1 Barrack Lane, 81-83 George Street Build-to-Rent Development (SSD-79439459): Response to Submissions – Heritage

This letter has been prepared to respond to the RTS themes broadly and specifically submitted by agencies and City of Parramatta Council as outlined in the key issues letter by the Department of Planning, Housing and Infrastructure, dated 24 December 2025. It addresses both built heritage and archaeological issues.

GROUND FLOOR CONNECTION TO THE STABLES

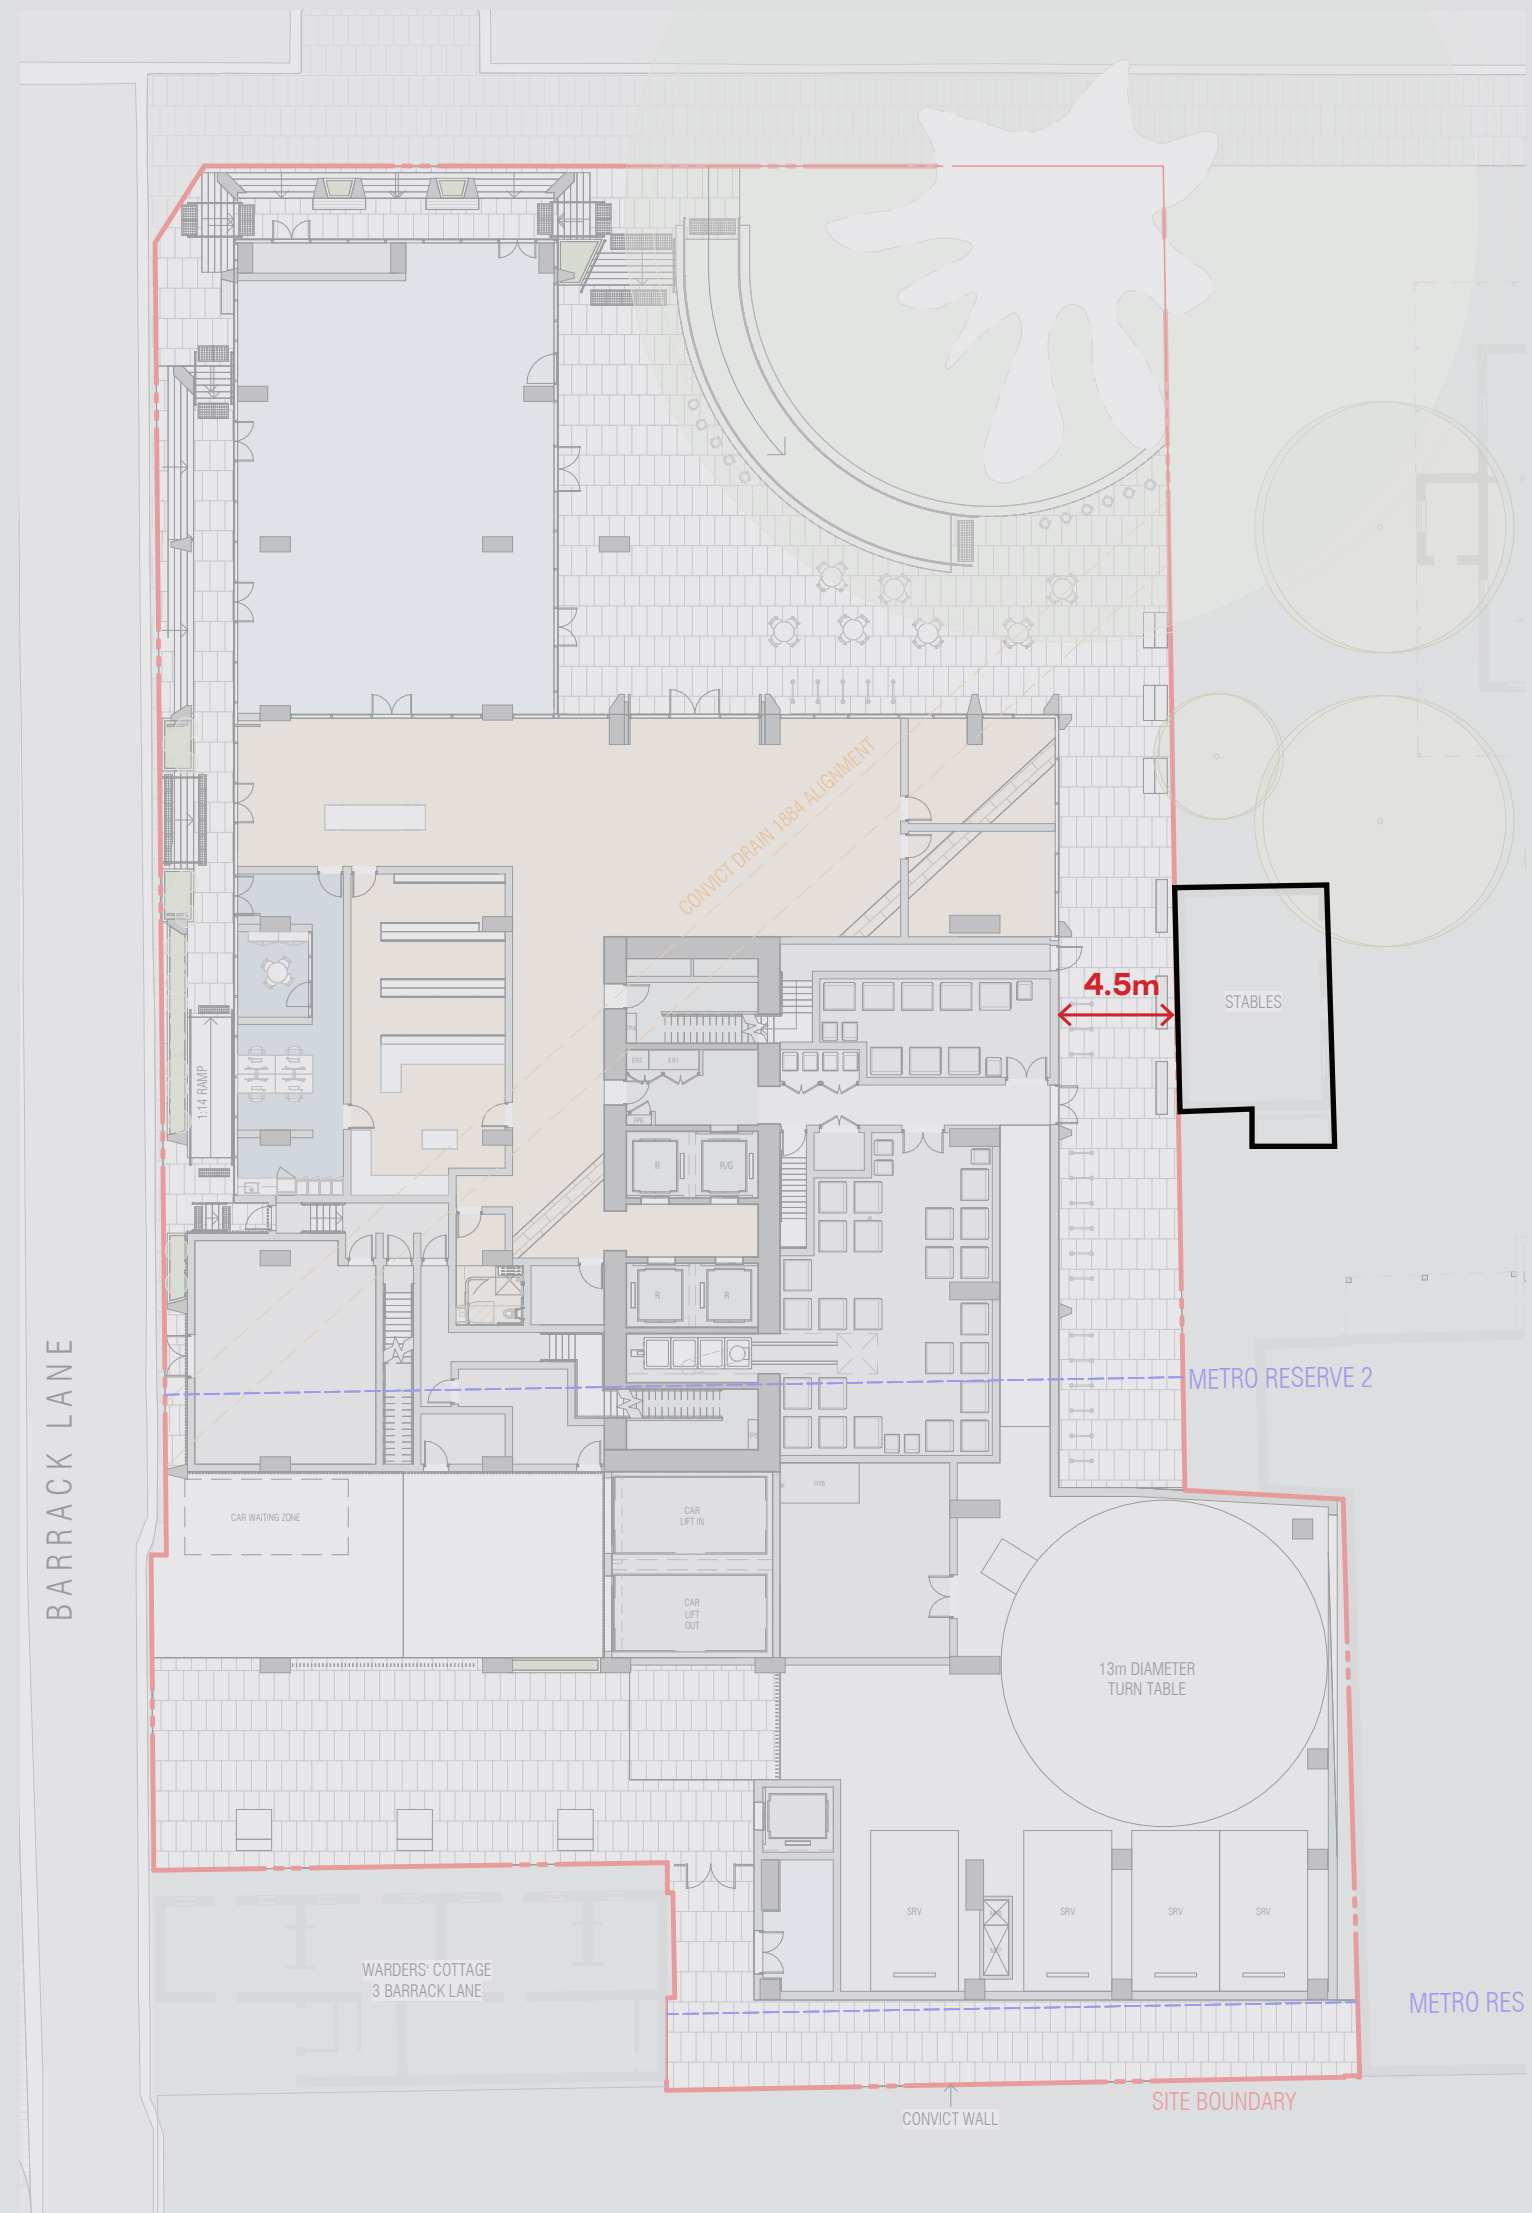
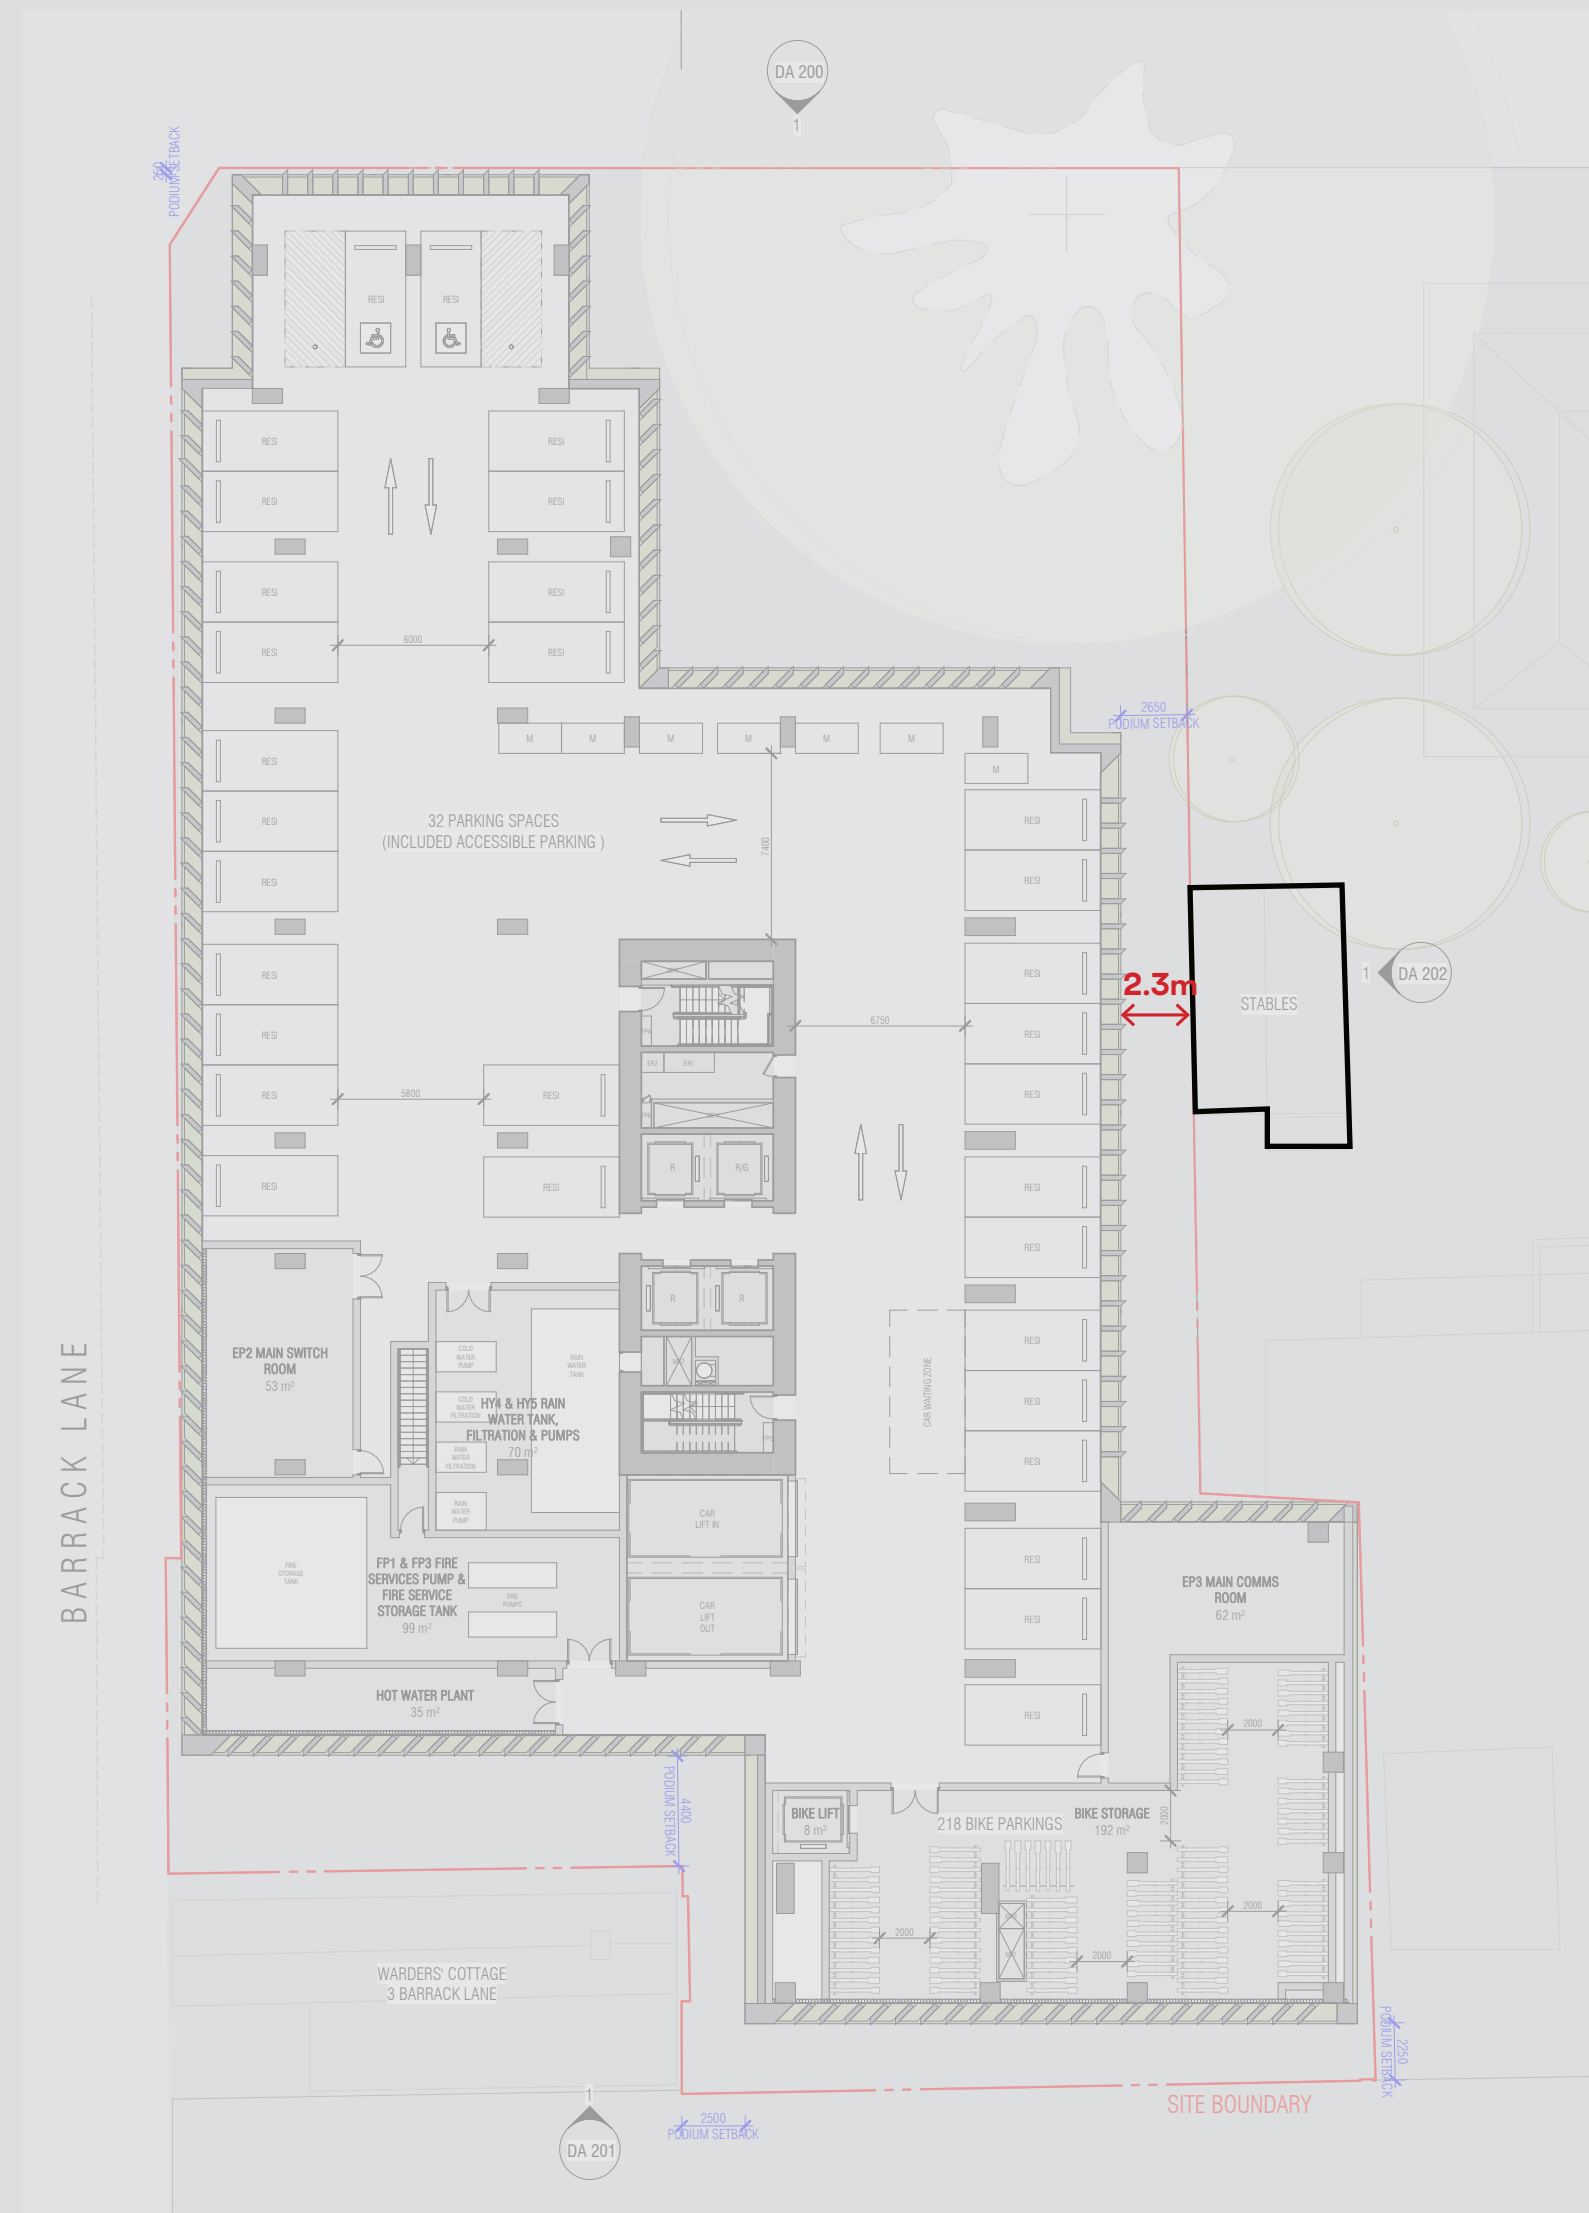
HNSW-6	Although there is a 4,500mm setback between the podium and the Perth House stables building at ground floor level, this setback is reduced to just 2,650mm for the upper levels of the podium. Please advise on why this setback cannot be increased to allow a wider visual buffer zone around the stables building.	The proposal is broadly consistent with the approved concept envelope for the subject site, (approved by the Sydney Central Planning Panel in December 2023 under DA/937/2022). The proposal provides a larger setback in the ground plane than the approved concept envelope. The ground plane is the primary contributor to the pedestrian experience and therefore, the larger setback at ground level improves the interface with the Stables from the approved concept envelope. With consideration

Item Ref.	Summary of Matters Raised	Response
		for this and the feedback provided, refinement of the design has been investigated to enhance the open space character adjacent to the Stables. A comparison of the current and revised proposed interface is demonstrated in montages prepared by FK, extracts of which are provided below.  Photomontage of SSDA scheme showing proposed building adjacent to the stables.

The larger setback for the podium from the ground level, ensures the Stables are able to be viewed and appreciated in the round as part of an activated ground plane. This is substantially enhanced by the revised scheme which removes the external colonnade adjacent to the Stables and rather aligns the structure with the building envelope, with the cantilevered soffit of the first floor at a compatible datum with the guttering of the Stables. Further amendment to the fenestration in the building return to the south of the Stables provides a neutral background against which the Stables will be visually distinguished and remain clearly legible as an outbuilding associated with Perth House. Views between Perth House and the Stables are unchanged. Noting
